5.0 Figure 4 Bicycle Parking

Government Architect NSW

Drawing Name:
**Landscape Plan
Lower Ground 4**

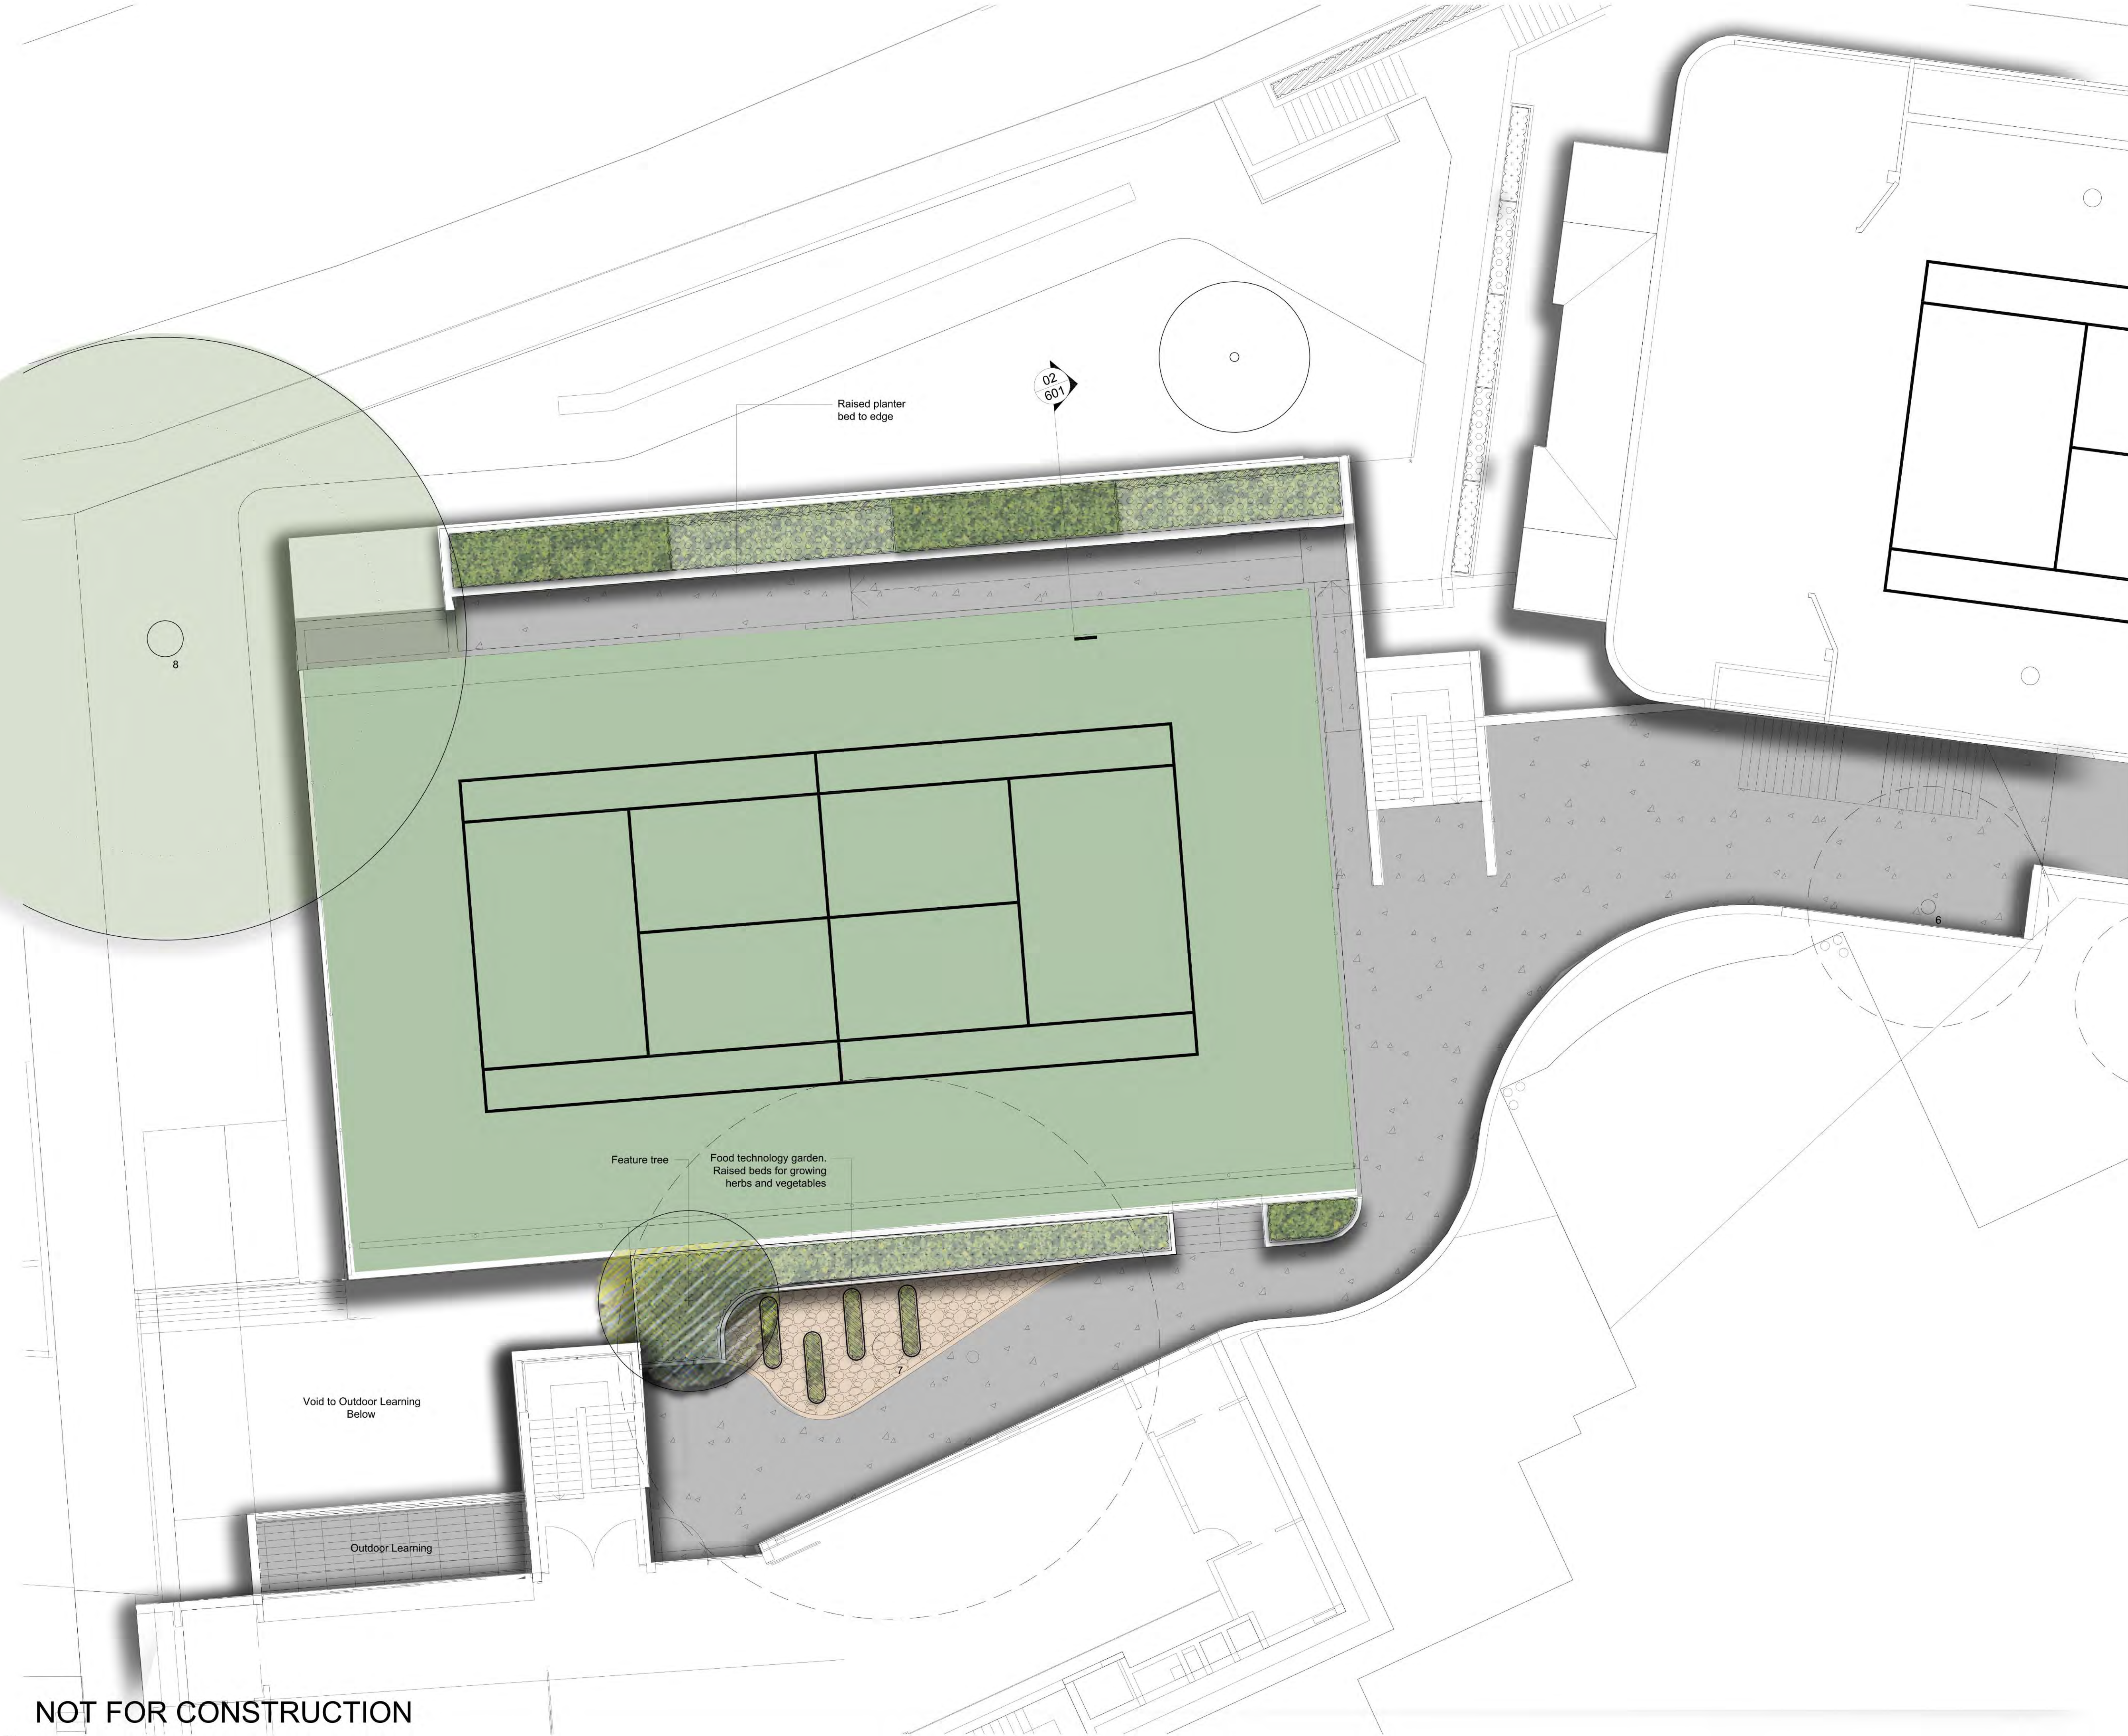
Comment :
No bicycle parking is provided. The transport and traffic survey showed that no students or staff arrive at school by bicycle, and that the school is very well serviced by public transport. However due to the density of the surrounding residential area street parking is in high demand and therefore all car trips and parking to the school should be discouraged. Bicycle parking and end of trip facilities should be provided.

Response:
Approximately 20 bicycle parking spaces are able to be provided in the existing sports storage area on the lower ground level of Centenary Hall with the end of trip facilities within the adjacent Lower Ground level of the New Learning Hub. Access is able to be provided directly off Elamang Avenue via a stair ramp on the existing stairs.
